DEVELOPMENT REVIEW BOARD
SUPPLEMENTAL SUBMITTAL

PROJECT NO. PR-2022-007229

Application No. SI-2022-01237

RE: Panda Express – S8-23-D20241
261 98th Street NW
Albuquerque, NM 87121
RE: DRB Planning Review – Resubmittal
DRB Project Number: 2022-007229
App. Number: SI-2022-01237

**SITE PLAN 1**

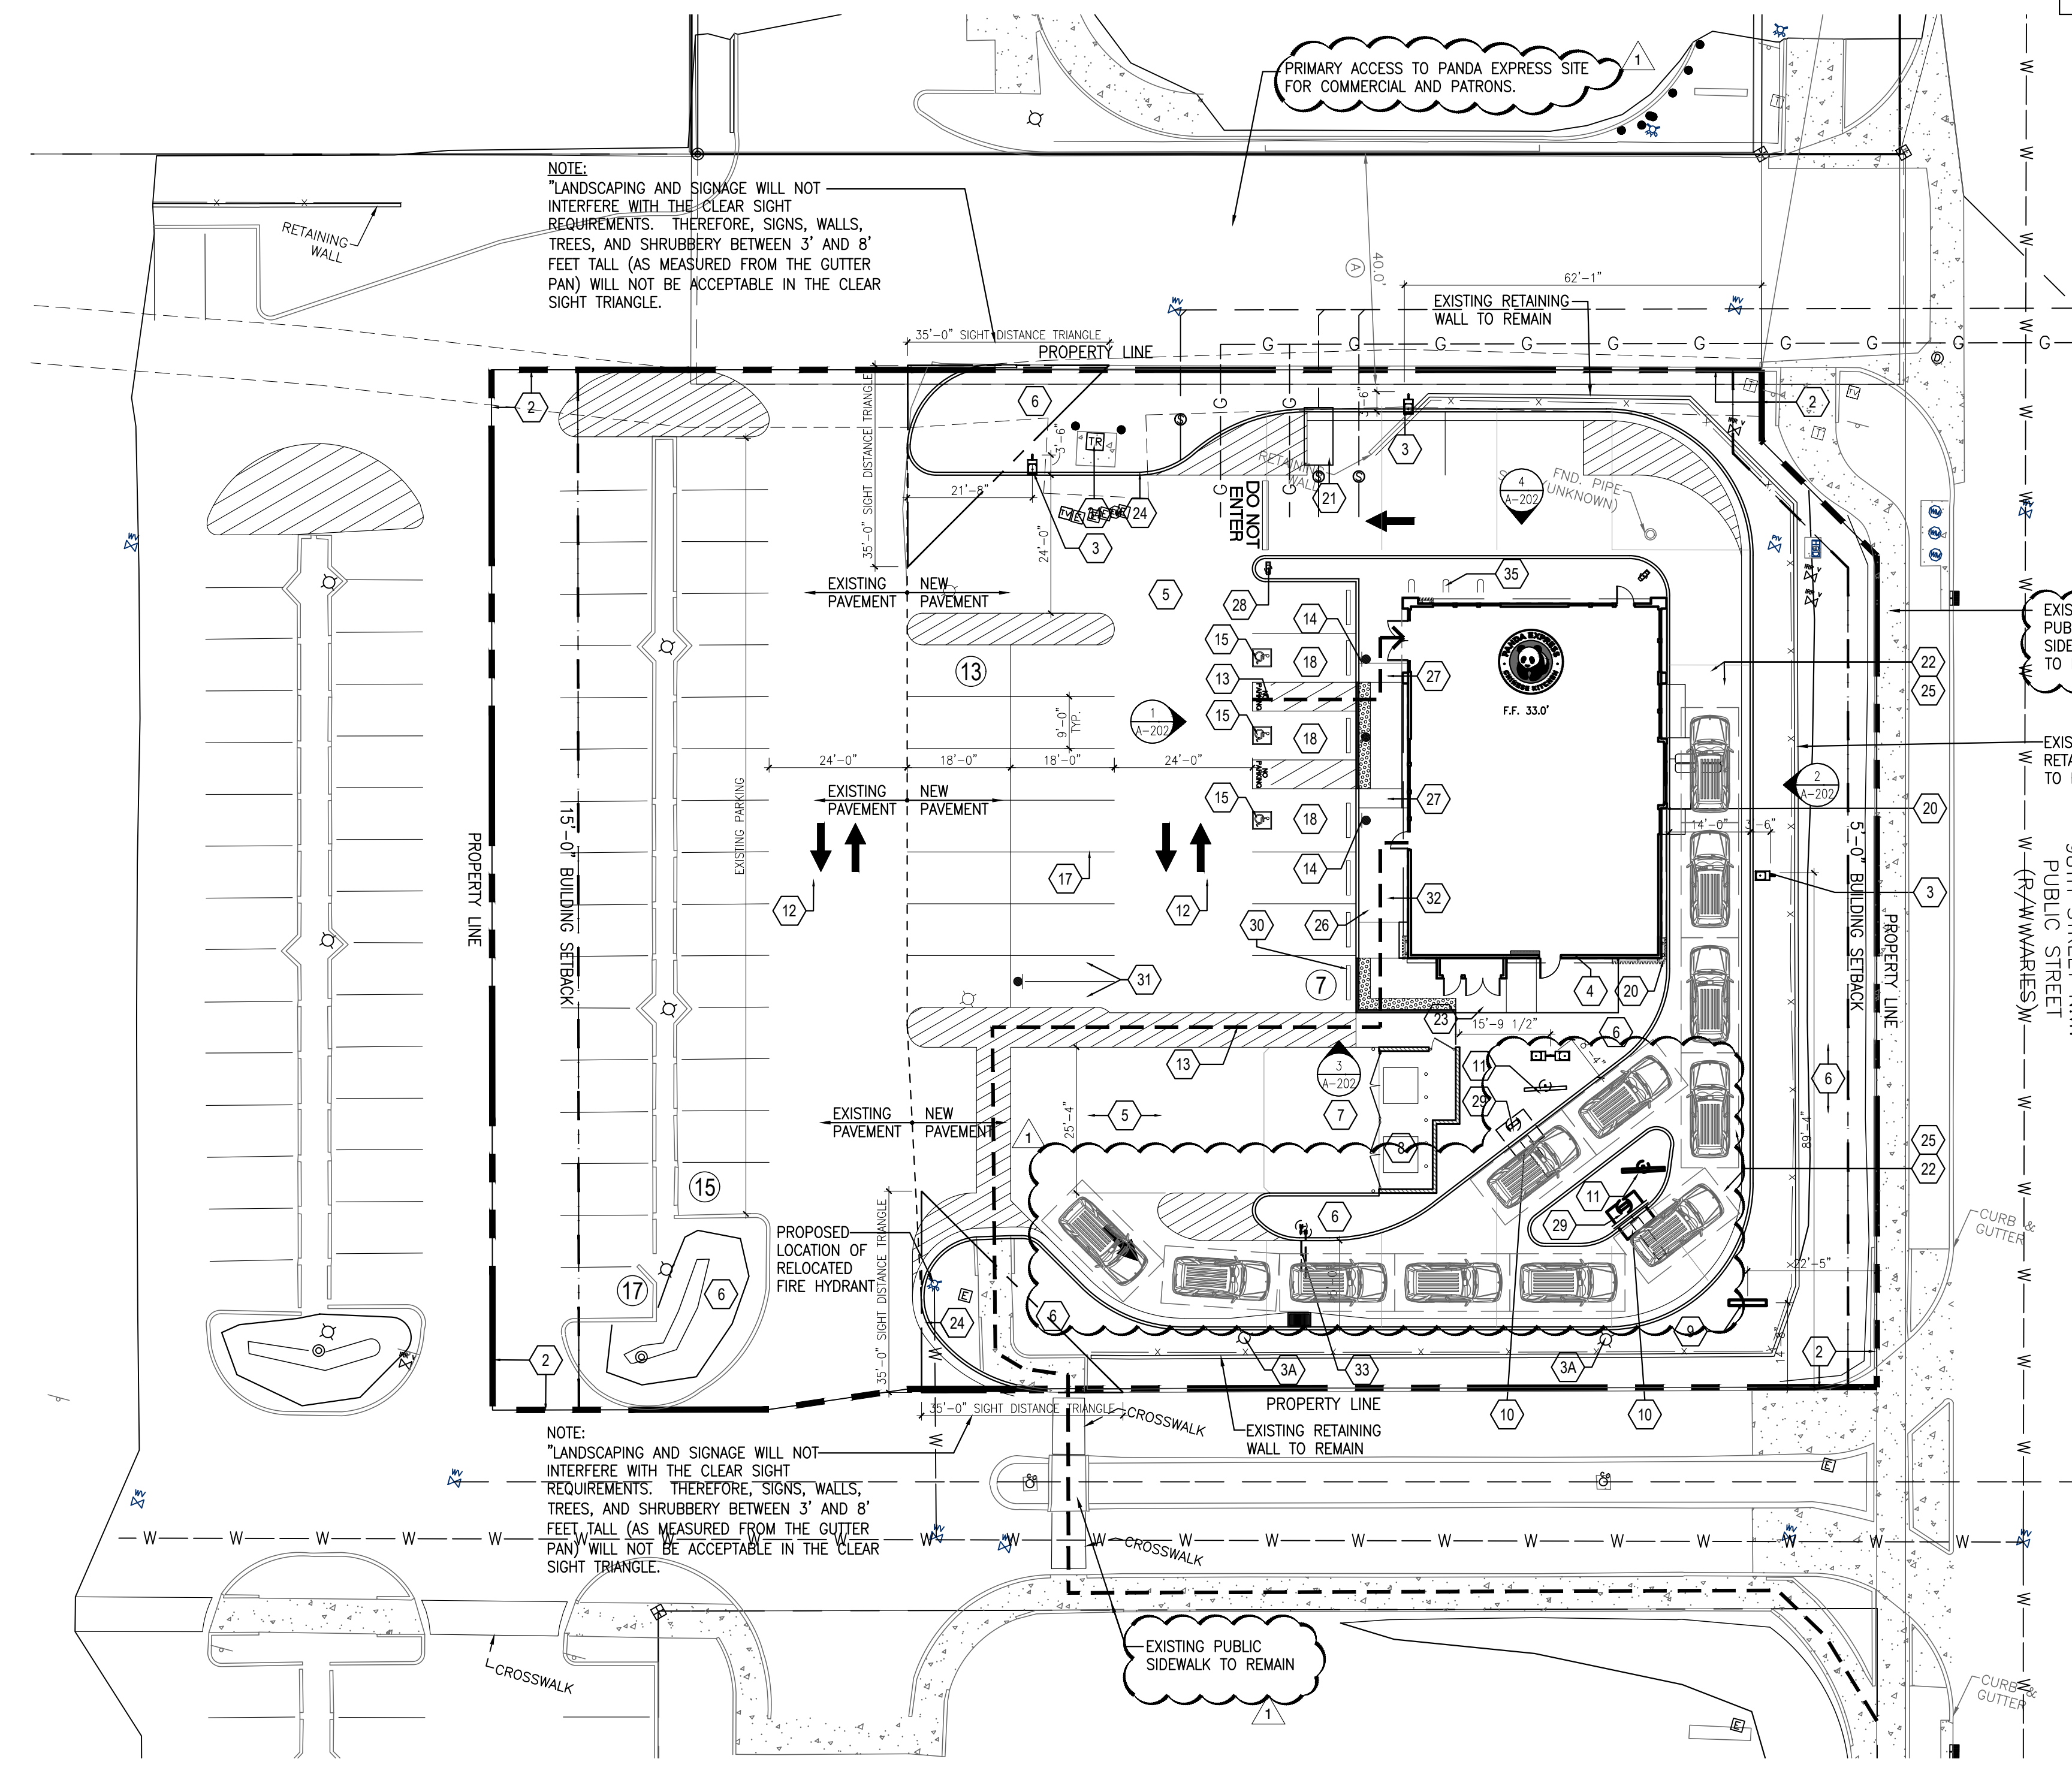
Response: *Acknowledge.*
- The Vehicle Stacking and Drive-Through requirements of 5-5(l) of the IDO must be met.
Response: *To comply with the requirements, we propose to increase the radii, by cross striping the area as you enter the queuing line at the south-west corner, and align it with the cross striped "finger tip" area so that the 12th vehicle is not within the driveway. As such, the access to the parking will not be obstructed, providing clear access and maneuvering clearances to vehicles. Please reference the revised site plan, sheet A-100, Architectural site plan.*
